FLOOD RISK RELATED COMMENTS ON DEADLINE 2 SUBMISSIONS IN RESPECT OF SCOTTISH POWER RENEWABLES EA1N AND EA2 PROJECT ONSHORE WORKS NEAR FRISTON

**For
SASES**

December 2020

Report Number: 201217

Infiltration Basin Structure

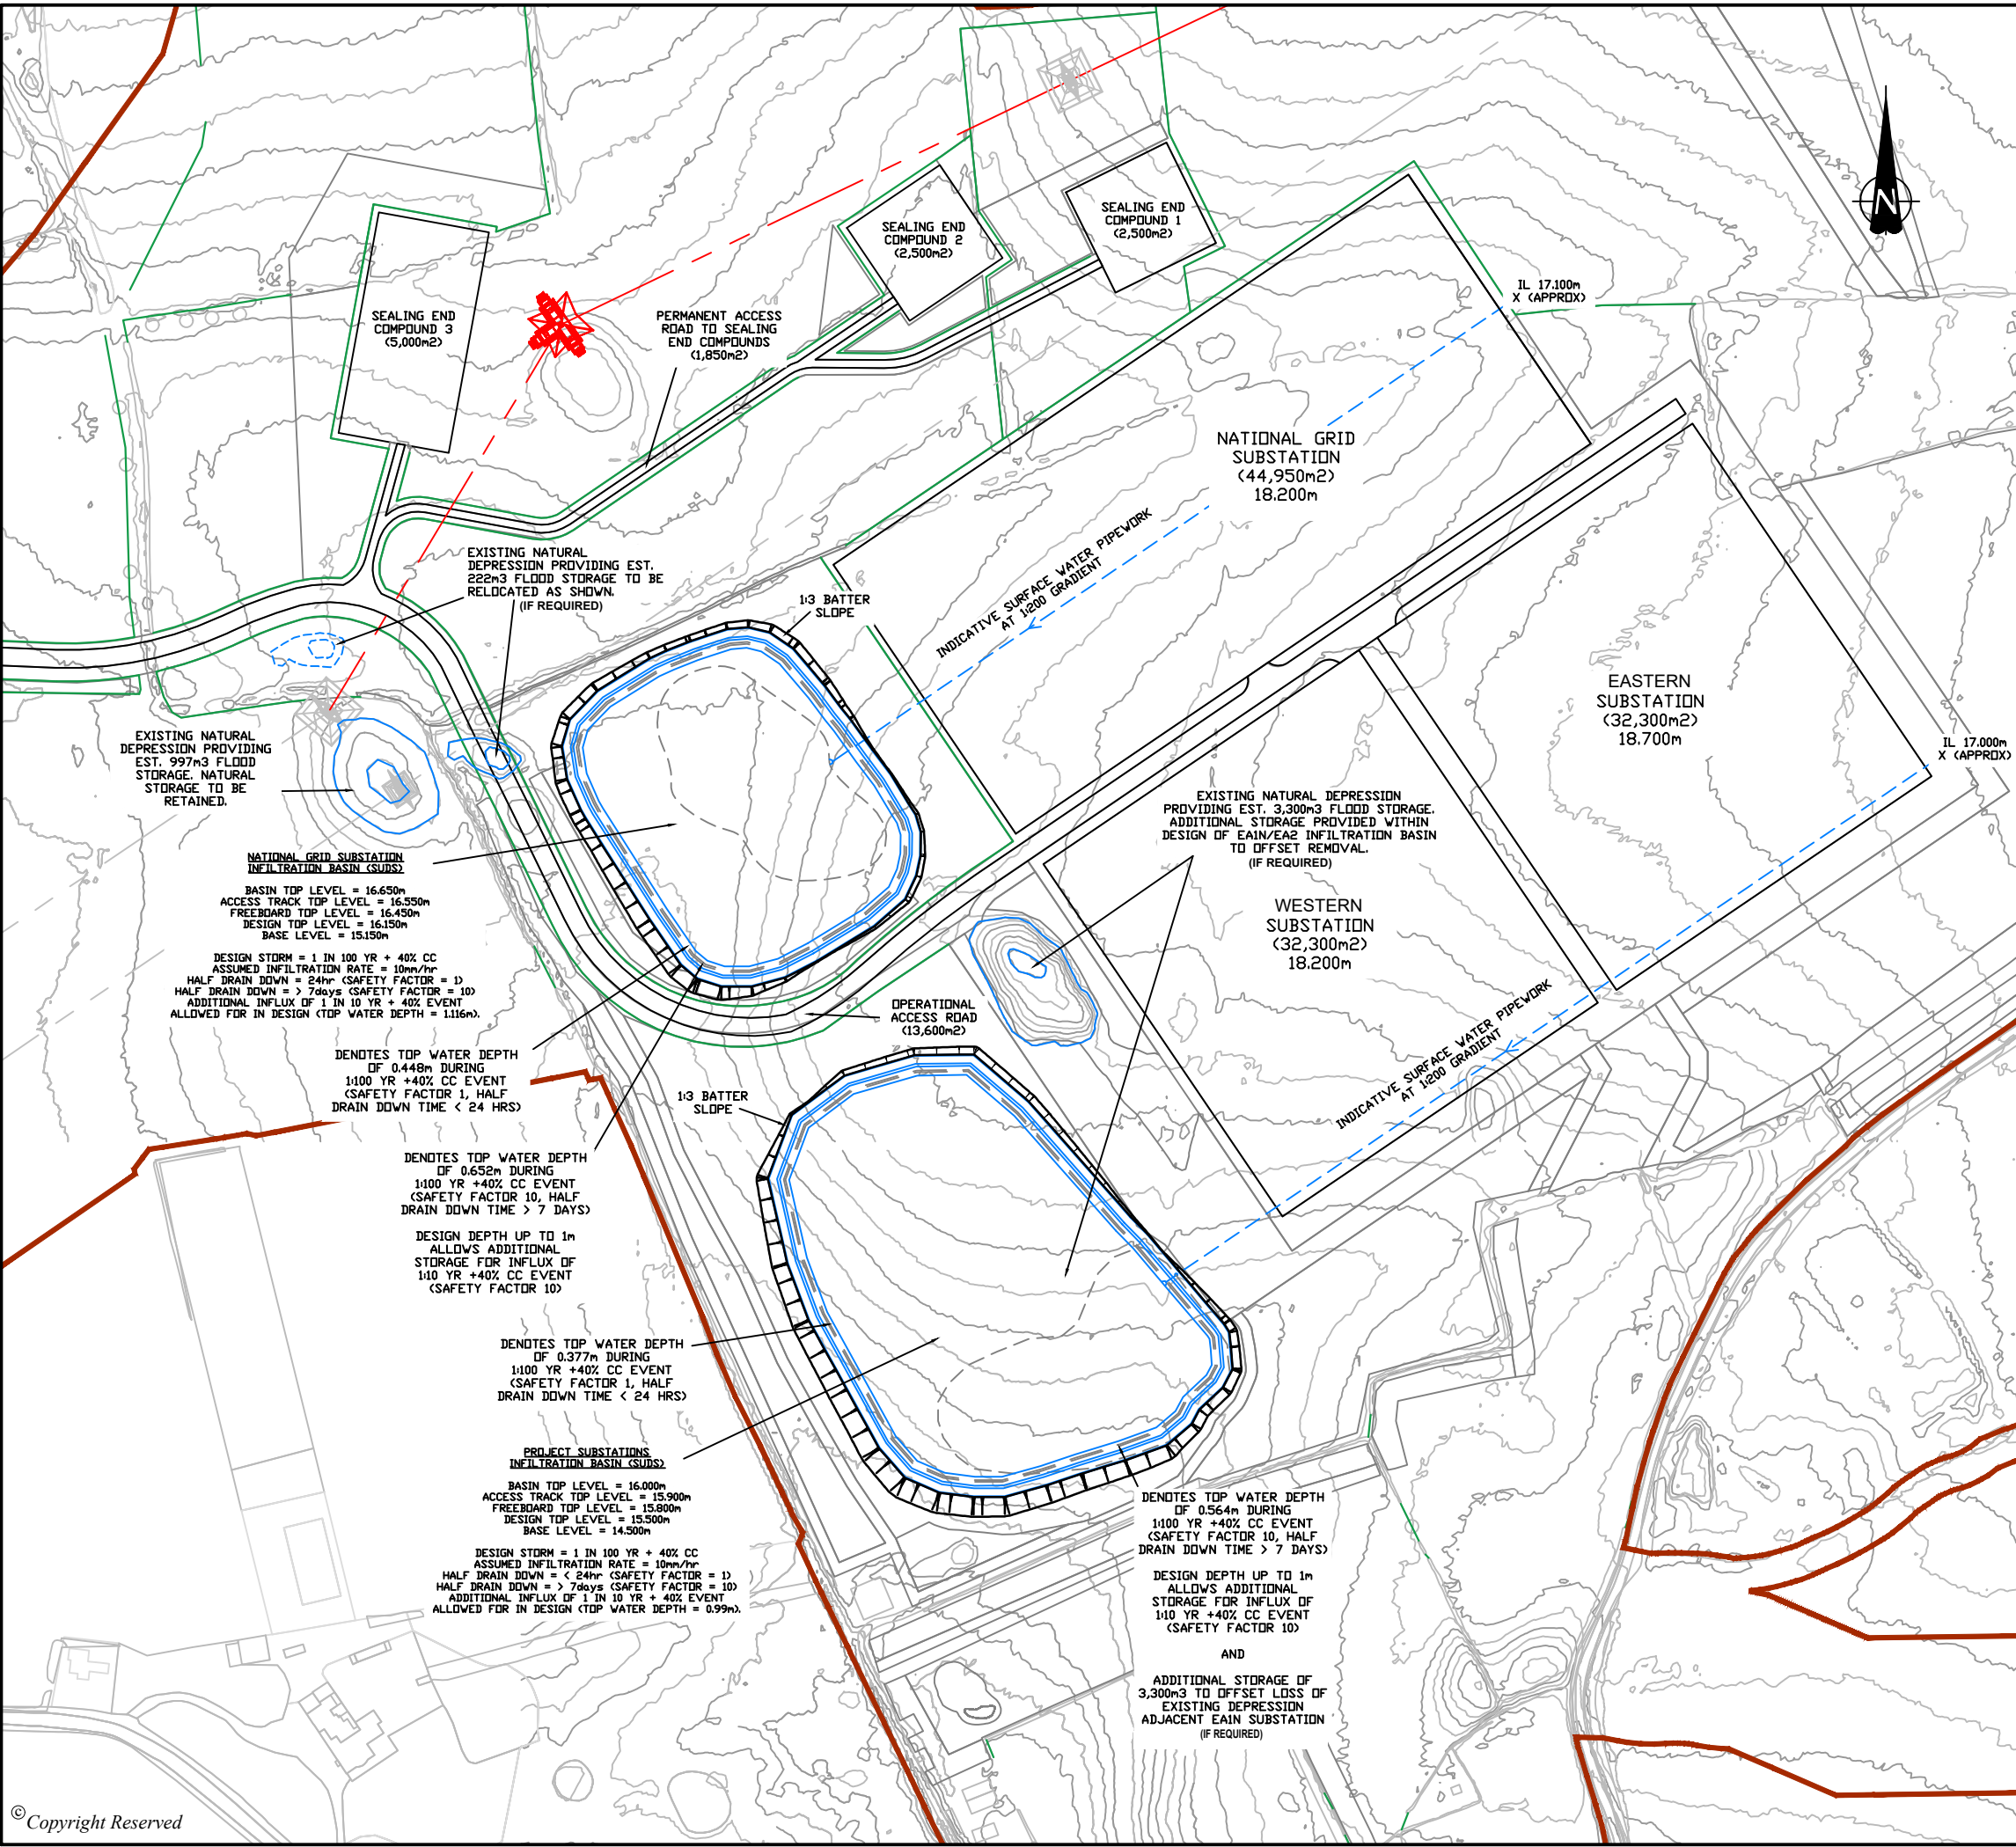
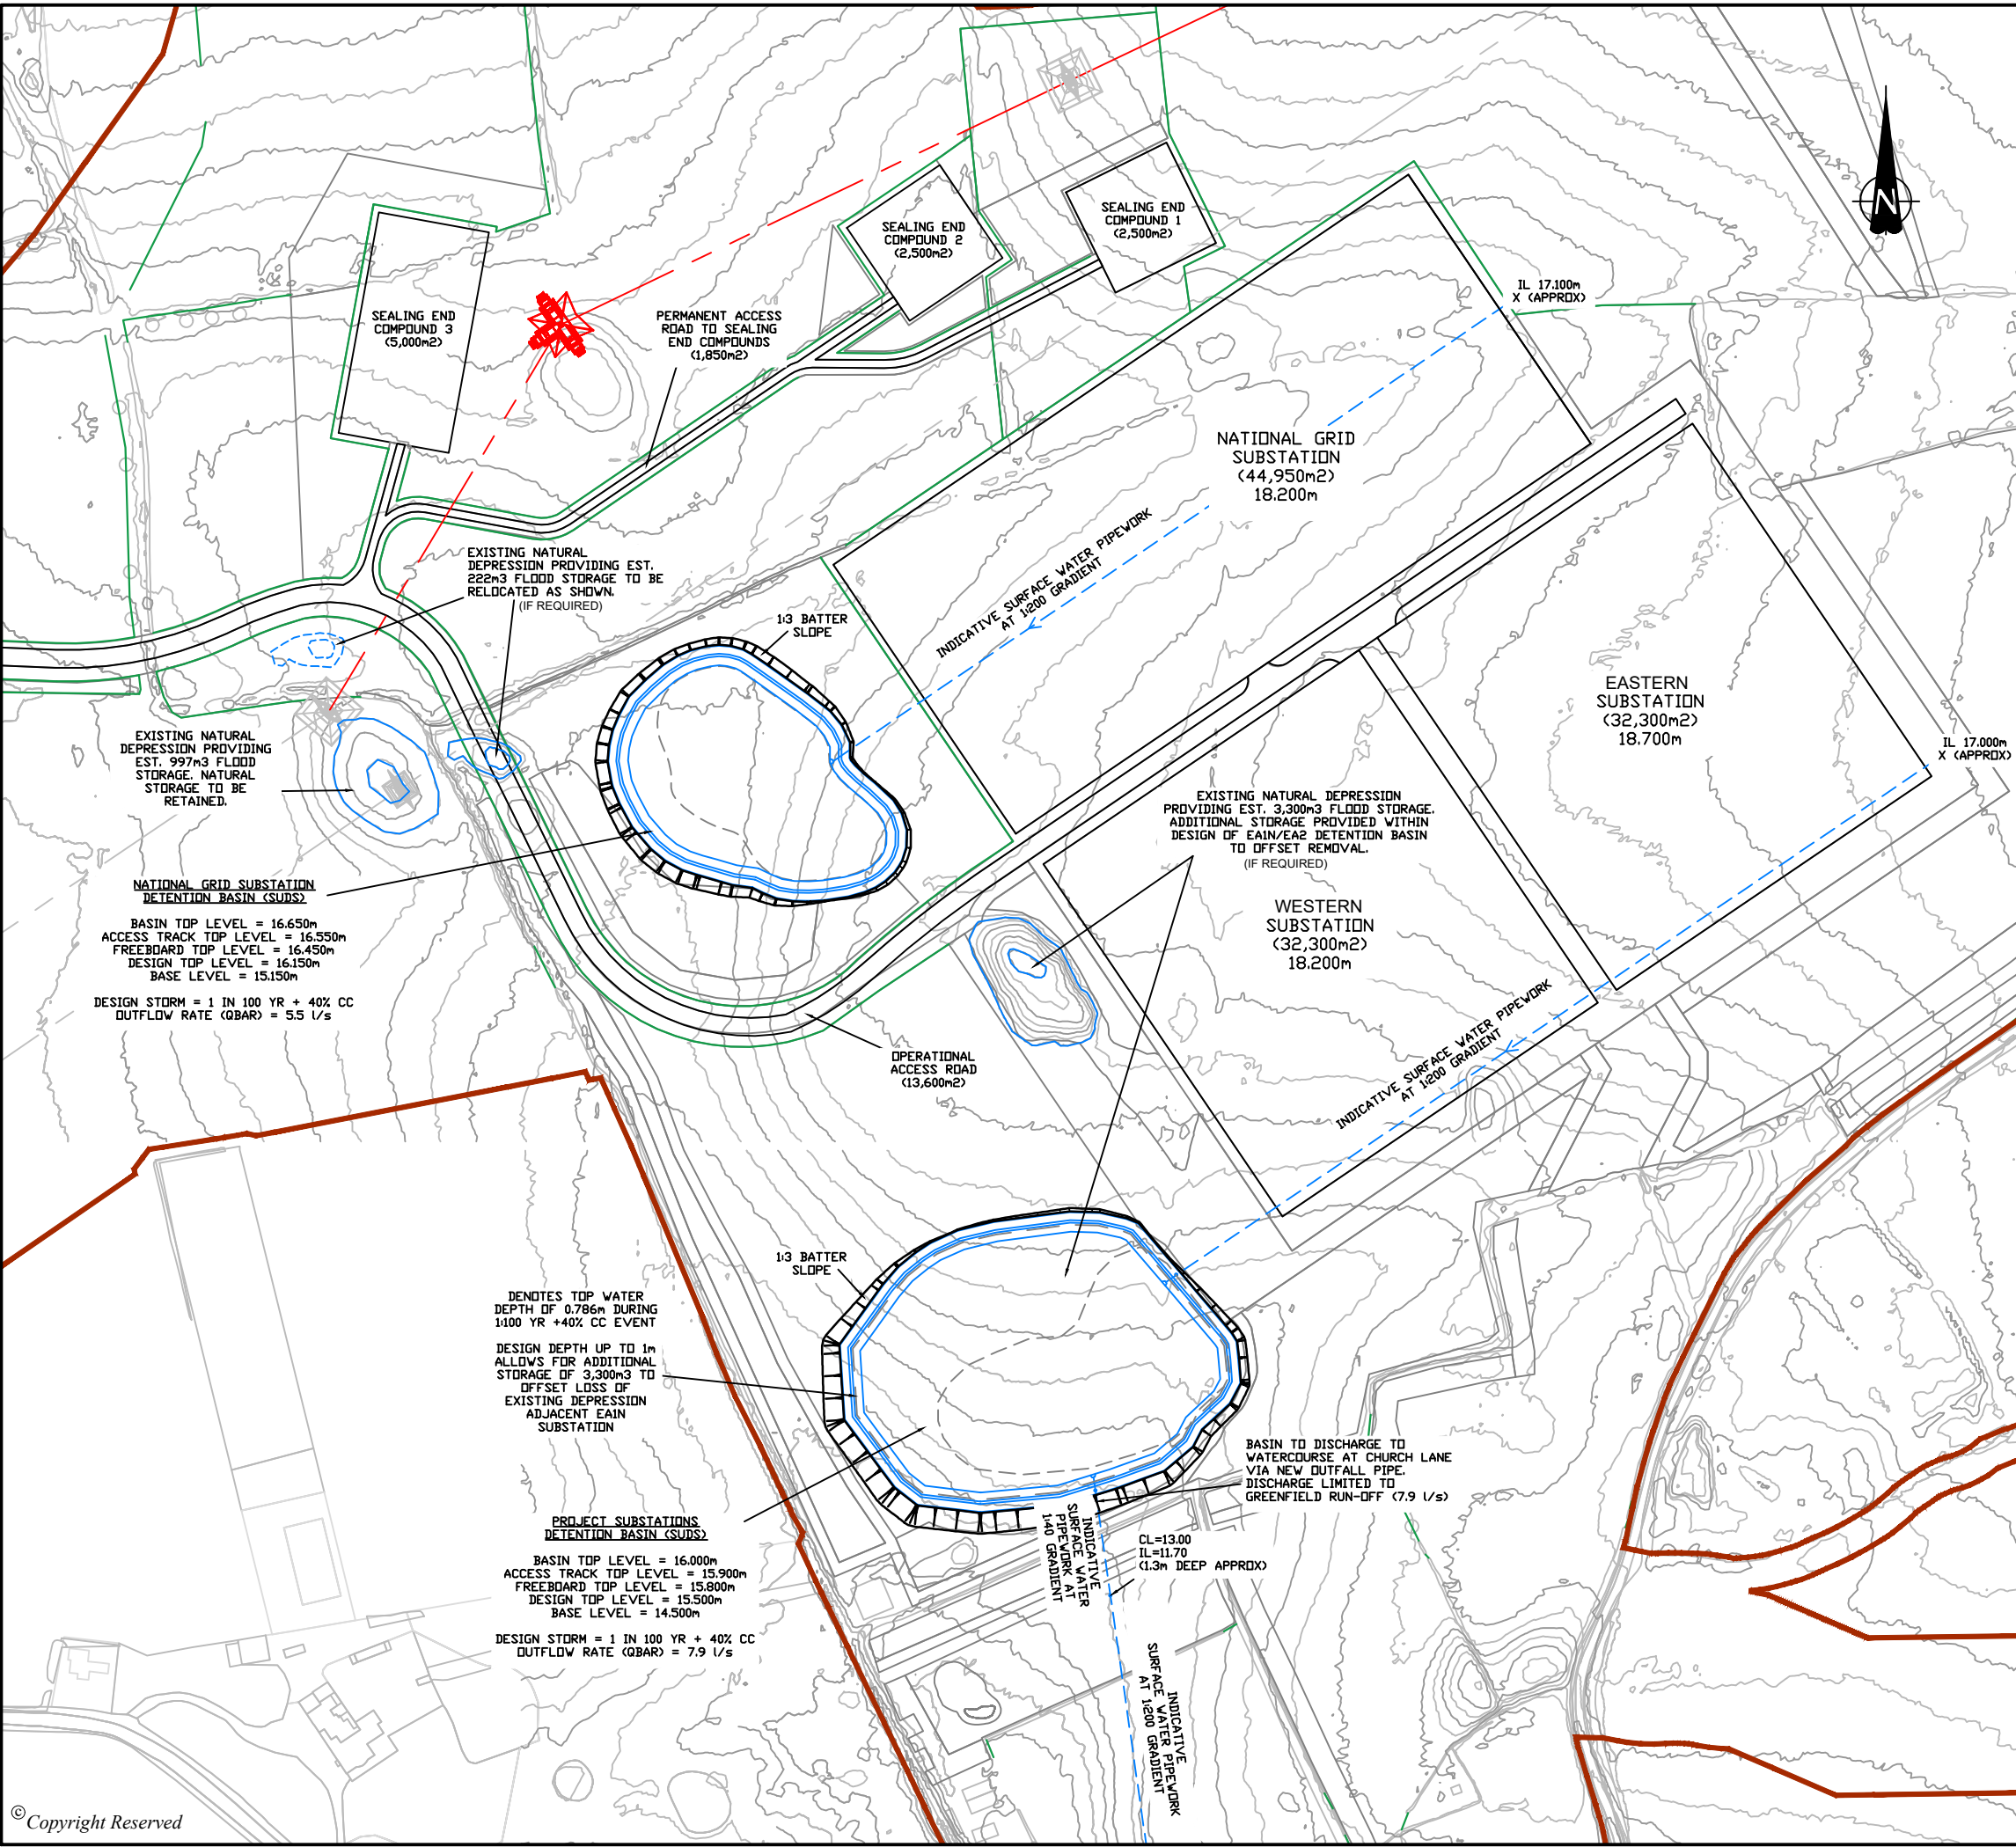
The Applicant then provides a series of MicroDrainage hydraulic model outputs. Each of these modelled scenarios shows 'Flood Risk' warnings due to the infiltration basin overflowing. No comment is provided by the Applicant on these results, but presumably the consequence is uncontrolled overflow of the basins, with turbid unattenuated flood flows, which will arrive in the village.

The Applicant's own modelling would appear to suggest the infiltration basins cannot contain and dispose of the required volumes and flows of generated site run-off, thus confirming they cannot perform as required and that the downstream flood risk is not mitigated.

TYPICAL INFILTRATION BASIN CROSS SECTION

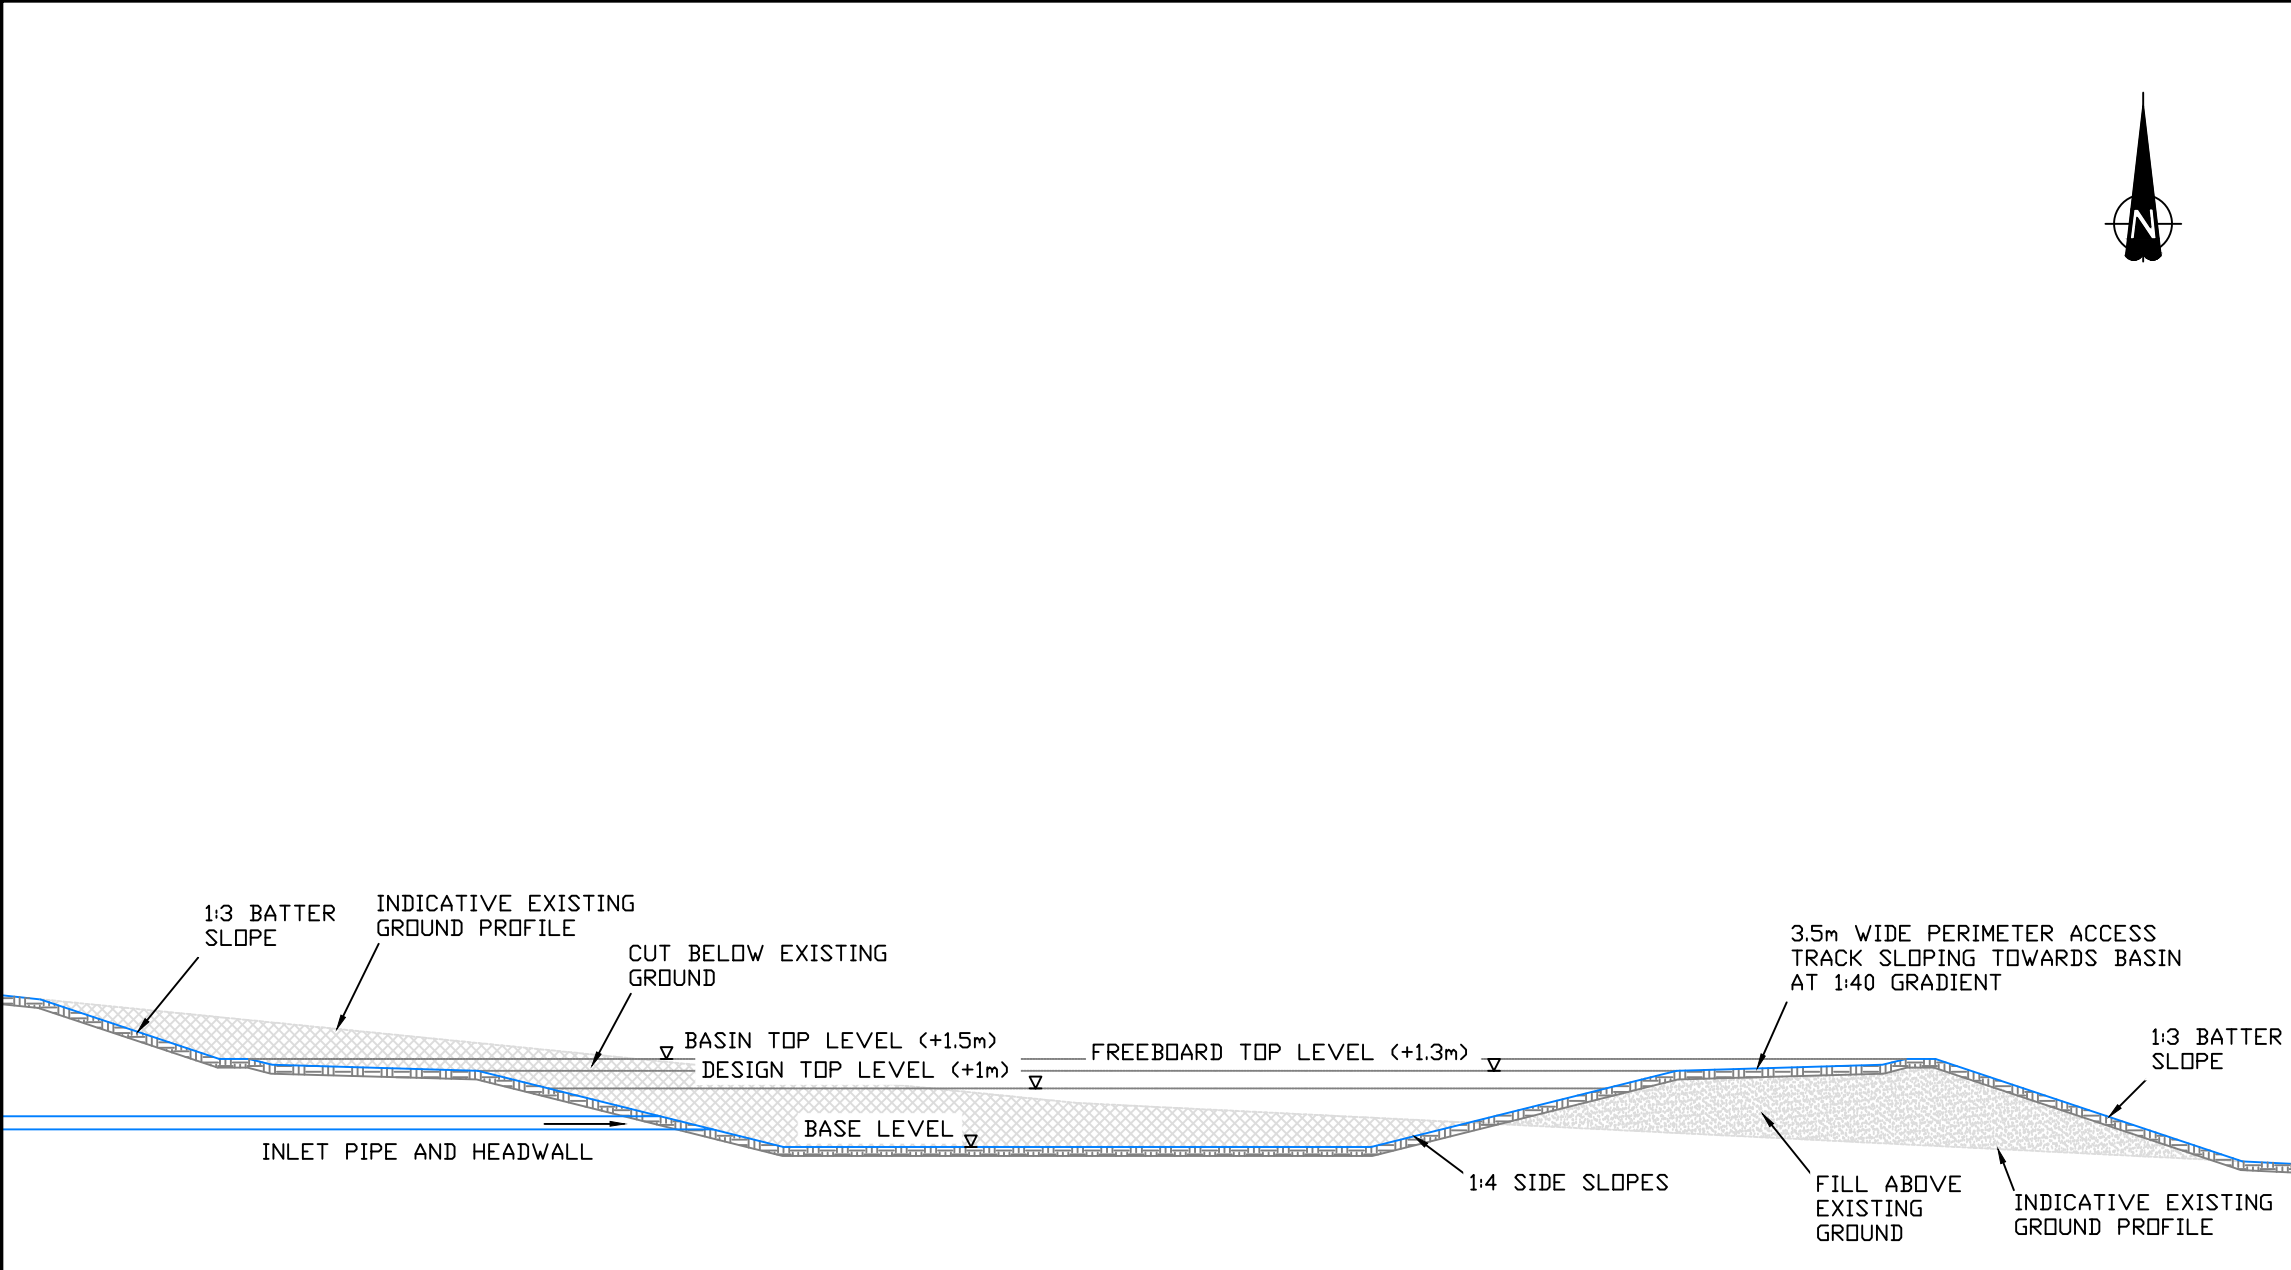
The Applicant has provided a 32 page report entitled SUDS Infiltration Note. The Note assumes that an infiltration rate of 10 mm/hr (10^{-6} m/s) is possible. All calculations assume this infiltration rate is achievable on site and can be sustained during storm events and storm seasons despite the likelihood of turbid run-off being generated from the site.

The Applicant has provided no evidence the infiltration rate is possible on the site, nor explained how turbid run-off will be managed to ensure efficacy of the infiltration basins.
